2024/0064

Address: 6 Holwick Close, Silkstone, Barnsley, S75 4NU

Description: 2 storey side extension, single storey rear extension, rear balcony and new window to front porch of detached 2 storey dwelling

**Proposed Front and
Rear Elevations**

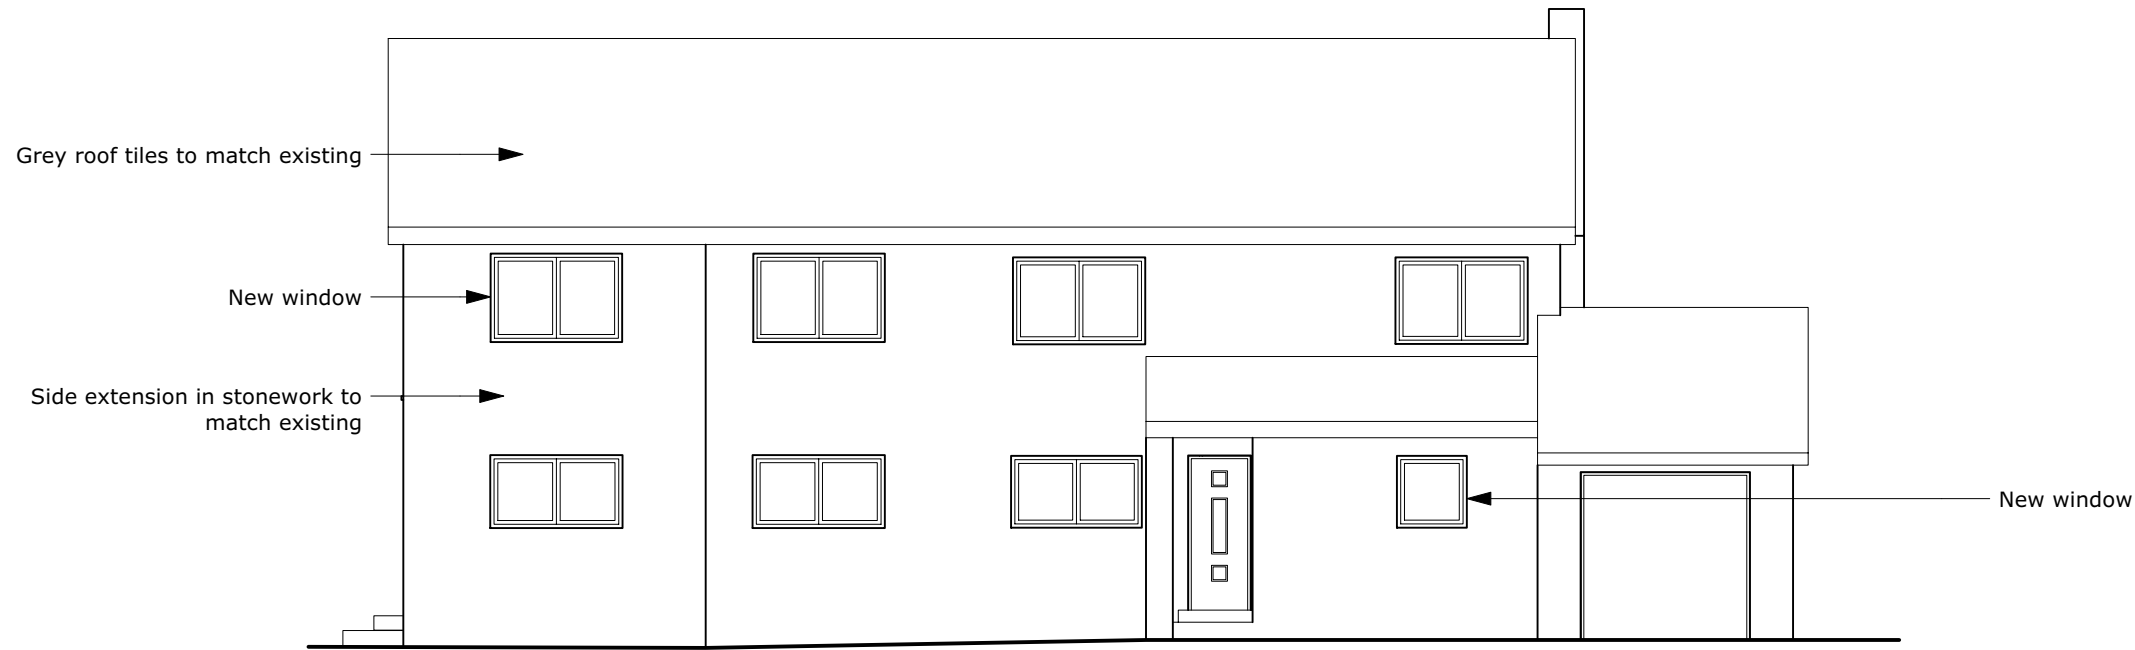
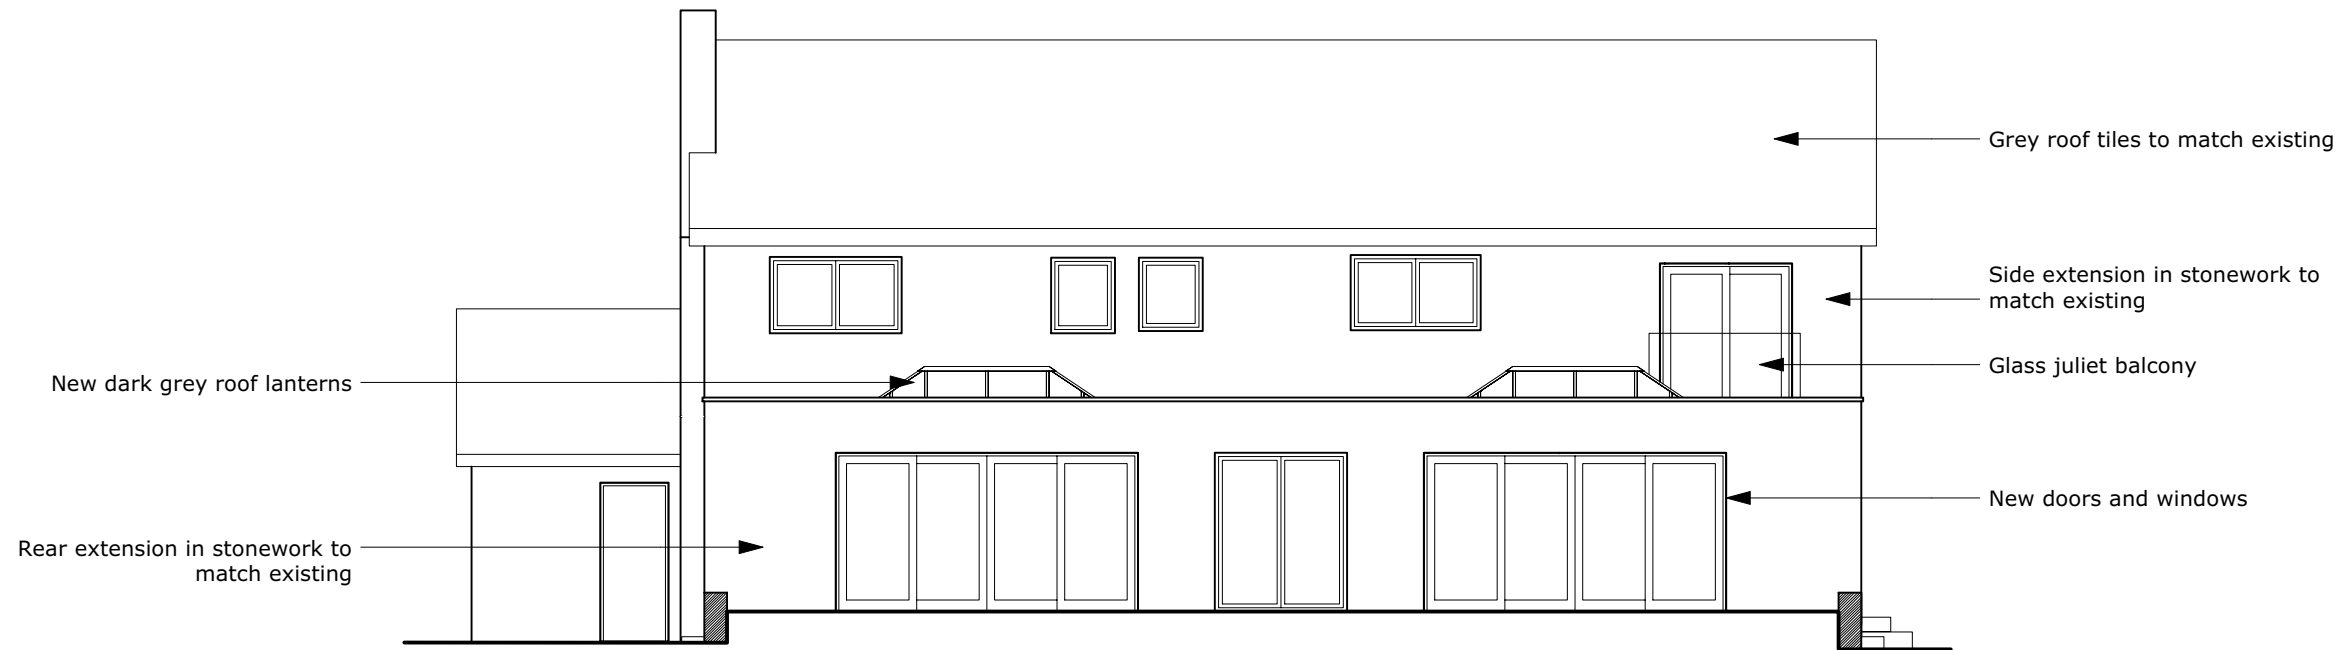
There is a Juliet style balcony proposed on the rear elevation, but by design, there would be no access on to the flat roof of the extension below or amenity space outside of the dwelling. As a Juliet balcony is akin to a window but which opens similar to that of a door, there would be no impact on the residential amenity of residents caused by the Juliet Balcony.

Currently the dwelling is a significantly large dwelling, in part due to previous extensions. However, currently due to its position within the cul-de-sac, it does not appear overbearing within the street scene, when viewed from a distance, such as from the junction of the street with Sunny Bank Road, this is predominantly due to the shielding provided by No.4 Howick Close. In contrast, it may be slightly dominant within the skyline when viewed from the rear, but due to the local topography, this is unavoidable and would affect other dwellings too. The neighbouring dwelling of No.7, whilst not as large as No.6, appears visually quite large and is certainly more dominant within the street scene. This is probably caused by the attached double garage wrapping around into the front porch located beyond the front elevation, and the dwelling's position at the center of the cull-de-sac.

Drawing
**Proposed Side
Elevations**

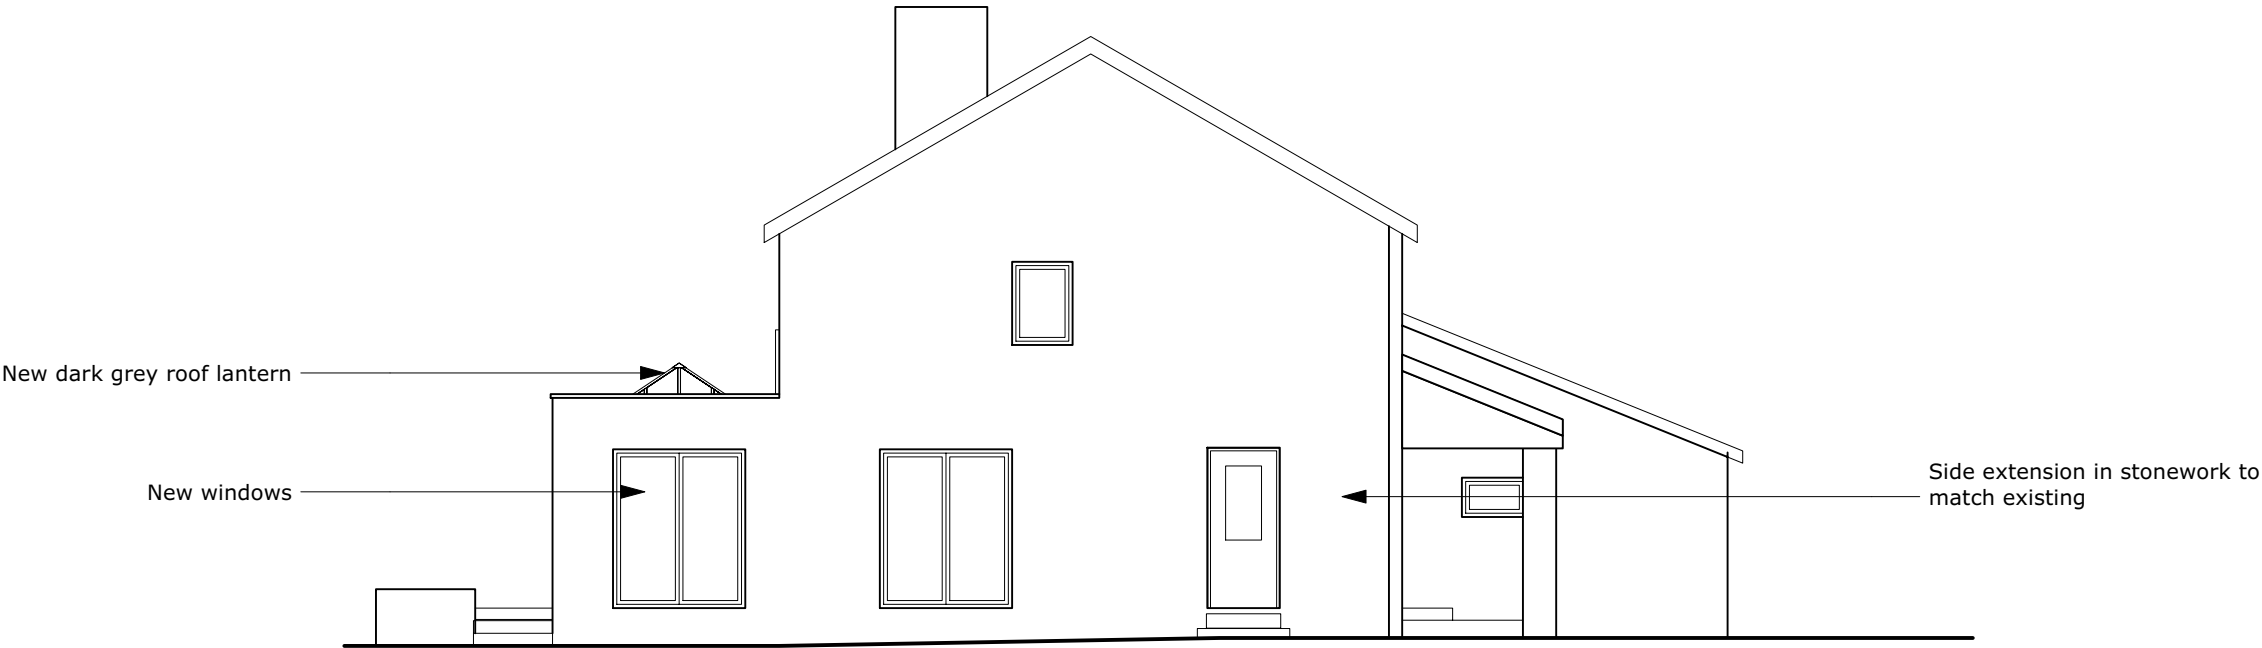
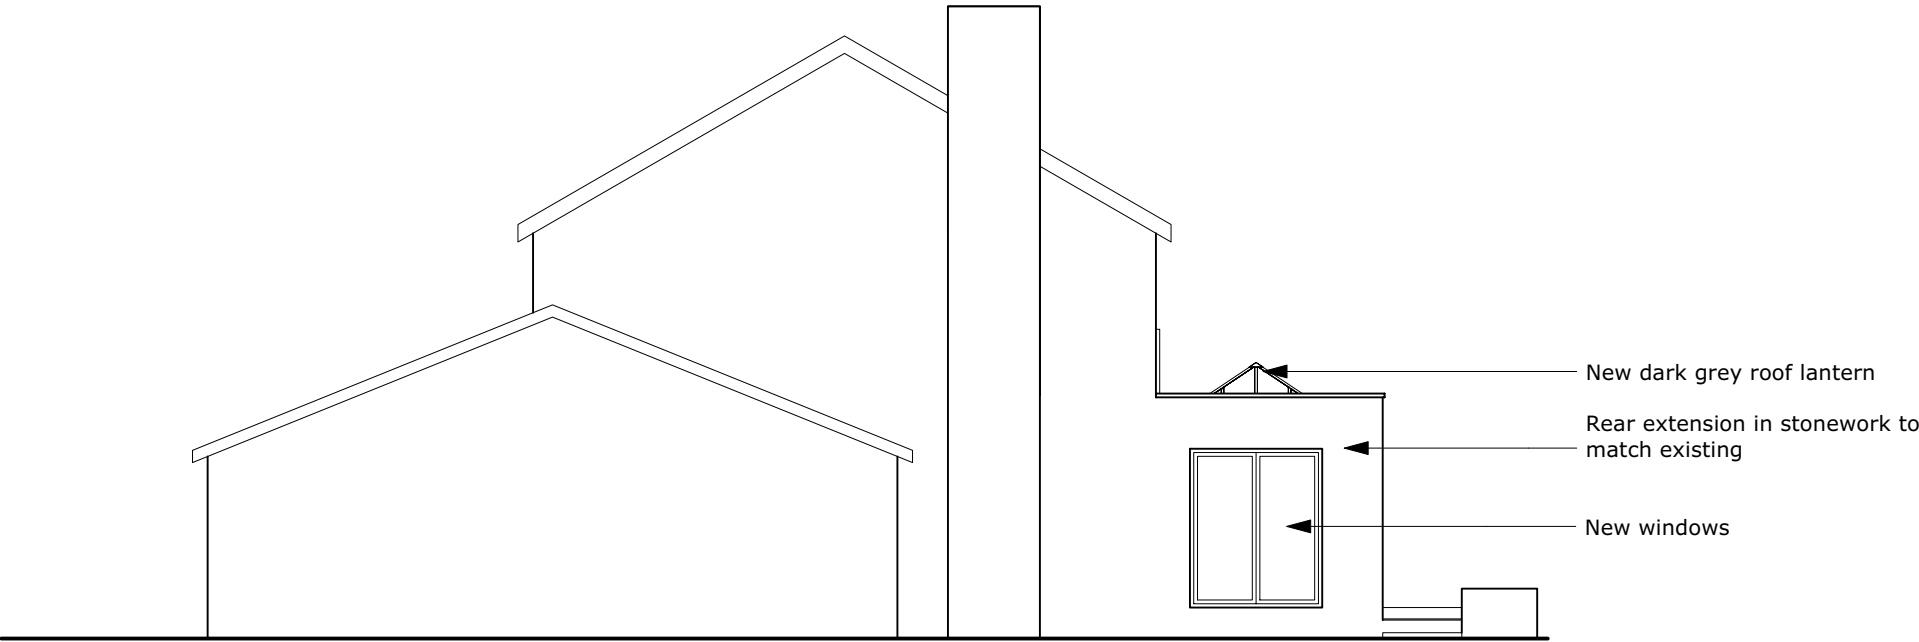
Regarding the two story side extension, which would be located near to the dwelling of No.7, overall the proposal may have an impact on the residential amenity of No.7, but as explained below, following additional information by the agent and viewing the exteriors and separation distance between both dwellings on a site visit, I am confident that the proposal would only cause insignificant or in a worst case scenario a modest impact on the residential amenity of No.7. The proposal is within reasonable proximity to that of the adjacent dwelling of No.7, but a minimum of 6m distance would be maintained between the two. The closest aspects of the dwellings will be the side elevation of No.7 and the extended section of front elevation of No.7. With No.7 only featuring a ground floor door and a small, obscured glass window, presumably of a bathroom on the first floor. In contrast consideration has been given to the rooms located within the extended front elevation of No.6. A utility room with a window would be located on the ground floor, whilst an ensuite bathroom, with a window would be located on the first floor. The applicant has confirmed they would be installing an obscure window, but this can also be conditioned within a decision notice. As such, along with an existing strong boundary between the dwellings, there would not be a concern of overlooking or privacy for either dwelling. The space between the side elevation of No.6 and the boundary treatment is approximately 3m and is predominantly a walkway to the rear garden, so potential overshadowing would be insignificant.

The side aspect of the proposed side extension does not extend beyond the building line of No.7, and with a very small first floor window within the master bedroom, overlooking of the rear garden of No.6 or other dwellings would be extremely limited. There are larger windows on the ground floor but the strong boundary between the dwelling and No.7 and a larger hedge (conifer) boundary between at the side elevation prevents overlooking of any dwellings. In relation to loss of light, due to the south facing nature of the rear garden of No.7 and the south to south west facing garden of

Usually, a set back and a set down in the roof line are required for extensions on the front elevation, to allow the extension to appear subordinate to the principal original dwelling. On this occasion a set back has been included but not a set down within the roofline. Given the position of the dwelling, at the end of the cul-de-sac and stepped behind No.4 it would not be in a prominent position in the streetscene. Whilst it would be desirable to have a set down as well as a set back, given the detached nature of the dwelling, and its position in the street scene it is not considered that a lack of a set down in this instance would be sufficient to recommend refusal of the application.
